Dear Inspector,

In the Examining Authority's Written Questions the Woodland Trust has had two questions directed its way. Below I have provided a response to these questions and their reference number.

Graphic 1-12 Cross section of River Arun and the Chichester to Littlehampton railway line trenchless crossing

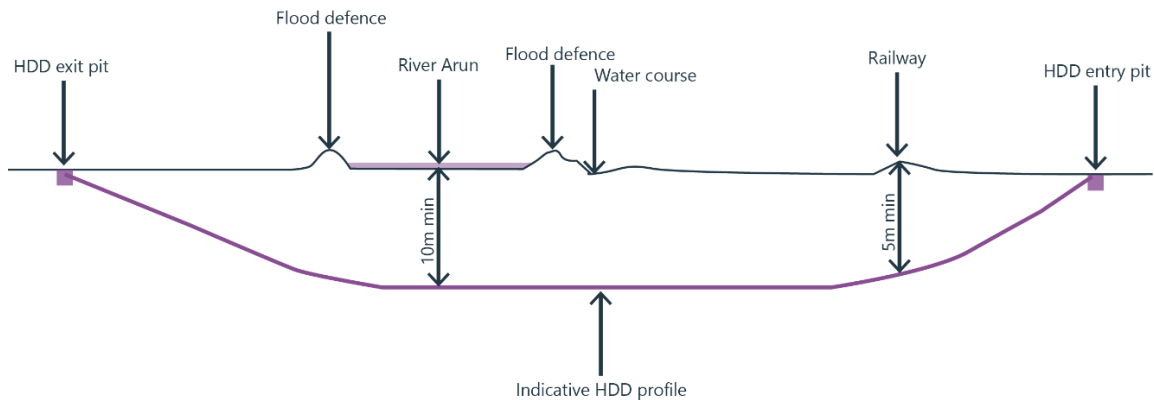
The Trust has been asked to explain whether it has any remaining concerns on the reliance on HDD or other trenchless technology. While we are satisfied that crossings will be undertaken at a depth of 6m and that this should not result in any impacts on the soil profile or other features of the ancient woodland, we do have some remaining concerns. Where such methods are used under ancient woodland, the Trust would have concerns with respect to maintenance of underground cables and pipelines where faults or malfunctions might occur. In such instances, would the applicant be able to fix or repair any faults without having to dig up the ancient woodland or disturb the features for which it is considered important, namely the ancient woodland soils?
